DEPARTMENT OF PUBLIC WORKS

MEMORANDUM

SUBJECT: Clint Short Plat SP-08-00054
REVISED COMMENTS

SHORT PLAT NO. _____
KITITAS COUNTY, WASHINGTON

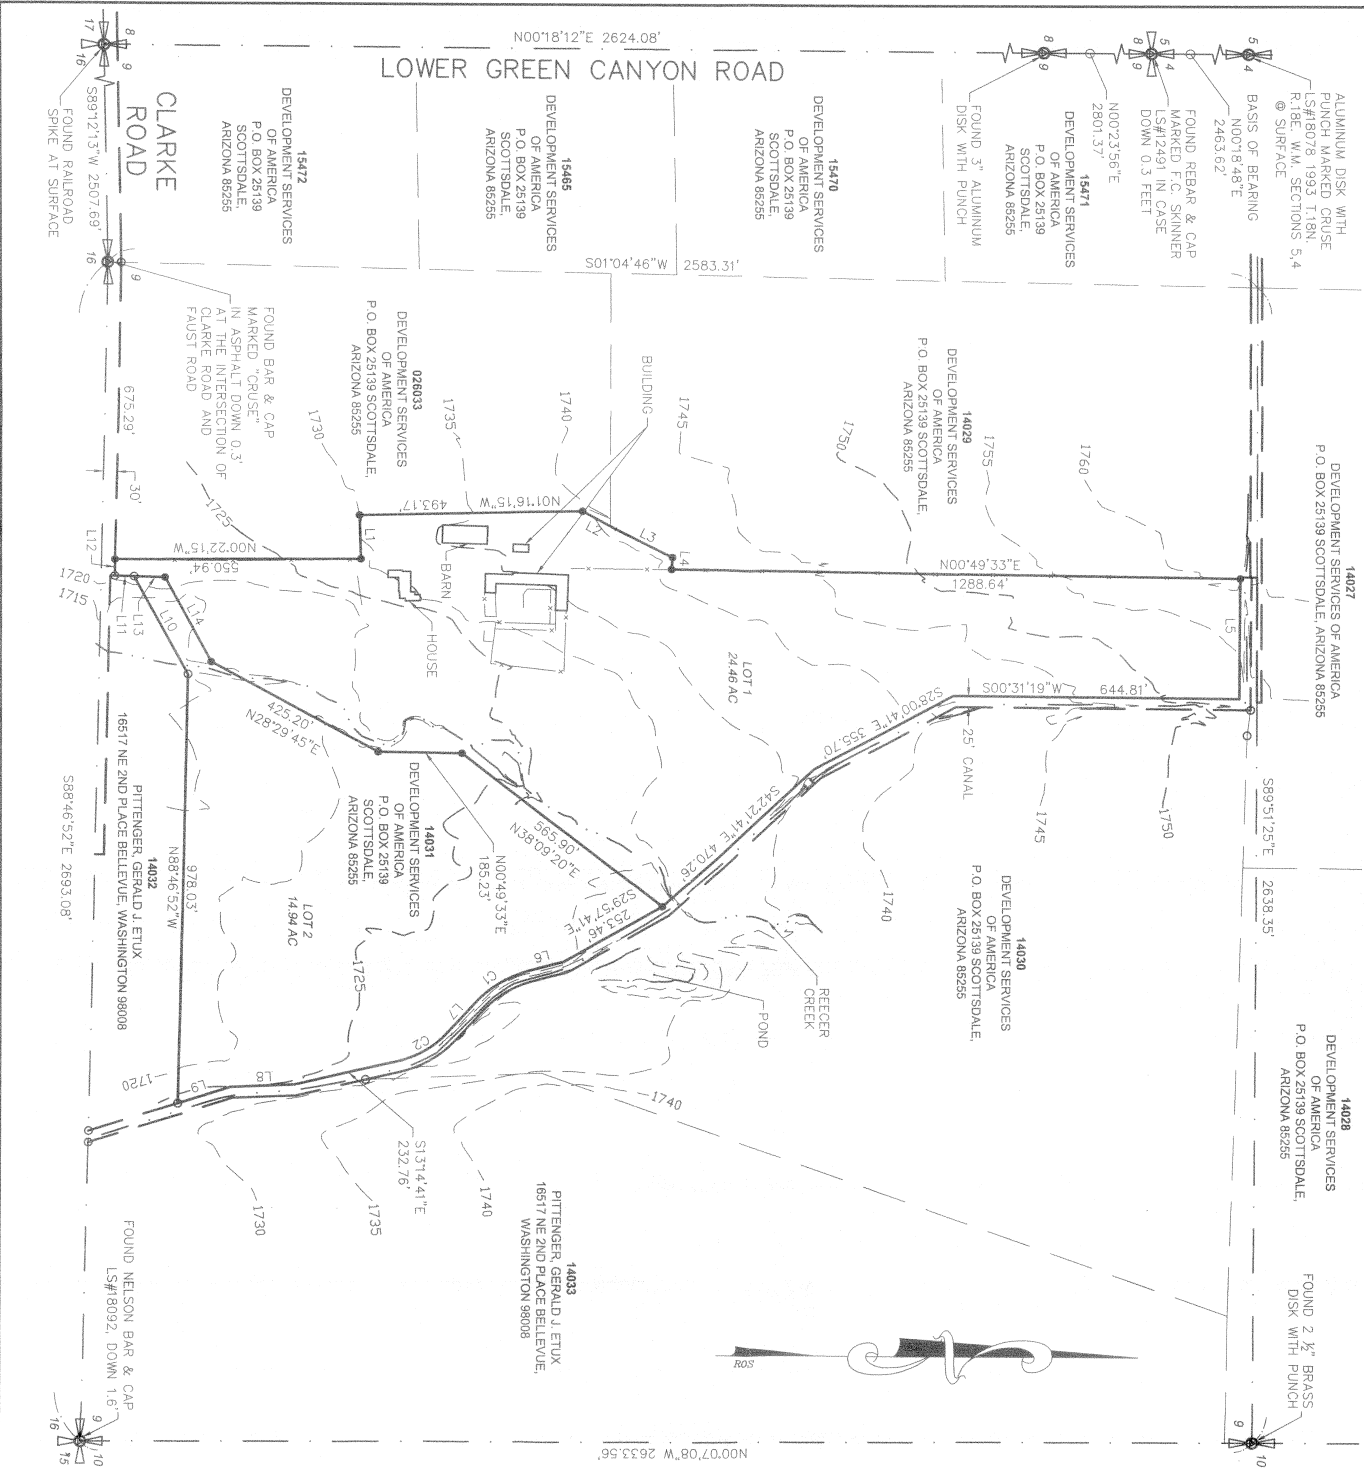
1. Plat Approvals: The Public Works plat approval box shall be revised to show the signature of the County Engineer. The acceptance block shall be as follows (per KCC 16.24.170):

5. Private Road Improvements: Access shall be constructed as a Low-Density Private Road. See Kittitas County Road Standards, 9/6/05 edition.
 - a. Access easements shall be a minimum of 60' wide. The roadway shall have a minimum width of 20', with 1' shoulders, for a total width of 22'.

- b. Minimum centerline radius will be 60'.
 - c. The surface requirement is for a minimum gravel surface depth of 6".
 - d. Maximum grade is 12%.
 - e. Stopping site distance, reference AASHTO.

6. Cul-de-Sac: A cul-de-sac turn-around having an outside right-of-way or easement diameter of at least 110 feet shall be constructed at the closed end of all dead-end roads serving 3 or more lots. The driving surface shall be at least 96 feet in diameter. Cul-de-sacs must also conform to the requirements specified by the 2006 International Fire Code. Contact the Fire Marshal regarding any additional cul-de-sac requirements.
